## City of Albuquerque Stormwater Construction Site Inspection Report

ESC File No.	H17E097	Project Name:	Carlisle Crossing		
NPDES Id. No.	NMR1005HJ NMR10040H	Location:	2100 Carlisle Blvd. NE		
3/30/2023	Owner	Contractor			
Operator	Carlisle Associates LP	Jaynes Corp.			
Contact name & title	Dave Rosen C/O Joe Bernabeo	<a href="mailto:stetson.chandler@jaynescorp.com">stetson.chandler@jaynescorp.com</a>			
e-mail	<a href="mailto:jbernabeo@rosenmgmt">jbernabeo@rosenmgmt</a>	<a href="mailto:stetson.chandler">stetson.chandler</a>			
Contact Phone #	505-304-4516	432-249-0659			
COA Inspector	Doug Hughes	Start/End Time:	10:30pm		
Construction Phase:	Parking lot done, no construction, landscaping and building incomplete.				
Type of Inspection:	<input type="checkbox"/> Regular	<input type="checkbox"/> Storm Event	<input type="checkbox"/> Past Storm Event >0.25"	<input type="checkbox"/> 311/Complaint	<input checked="" type="checkbox"/> Follow Up
Weather at time of inspection?		Clear		Temperature: ~	45

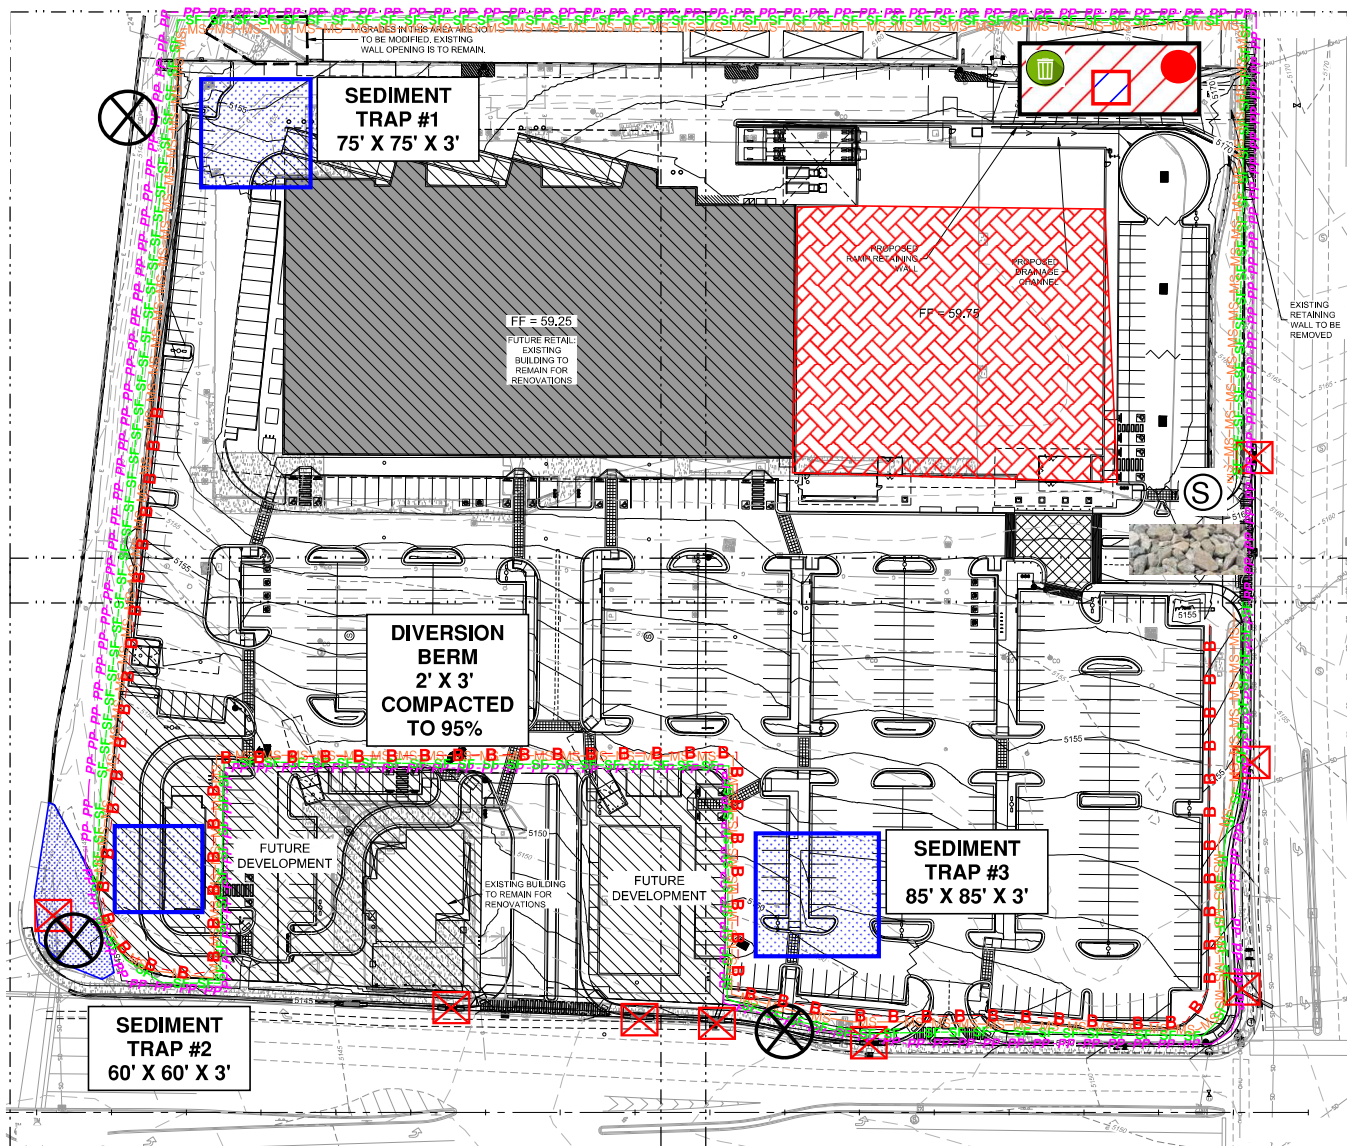
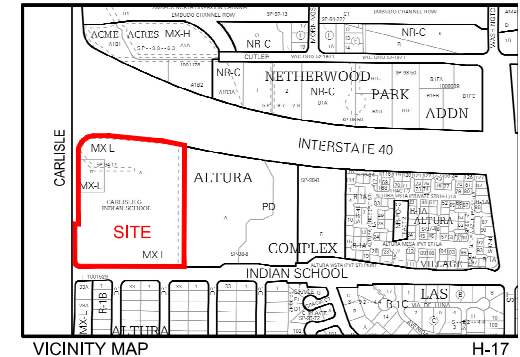
Estimated date of last storm 0.25" or greater		3/16/2023			
Item Number	Deficiency/ Corrective Action				
1	The NMDES ID# for the Owner is wrong on the Posting. It should be NMR1005HJ				
2	Please provide latest self-inspection report and all future reports.				
	General information comment - Loading docks next to east side of building, two Pad sites, and all landscaping are still disturbed and need to be stabilized. - You must continue permit coverage, self-inspections, SWPPP and BMP maintenance until the City determines that the Final Stabilization Criteria CGP2.2.14.c has been satisfied. Then you must remove the BMPs and send documentation of the Final Stabilization to the EPA with a Notice of Termination (NOT) per CGP 8.2 to end your coverage under the CGP. This step is independent of the Work Order. Please copy me with the documentation and the EPA's acceptance of the NOT at that time. In the meantime seed and Hydromulch are required per CGP 2.2.14.
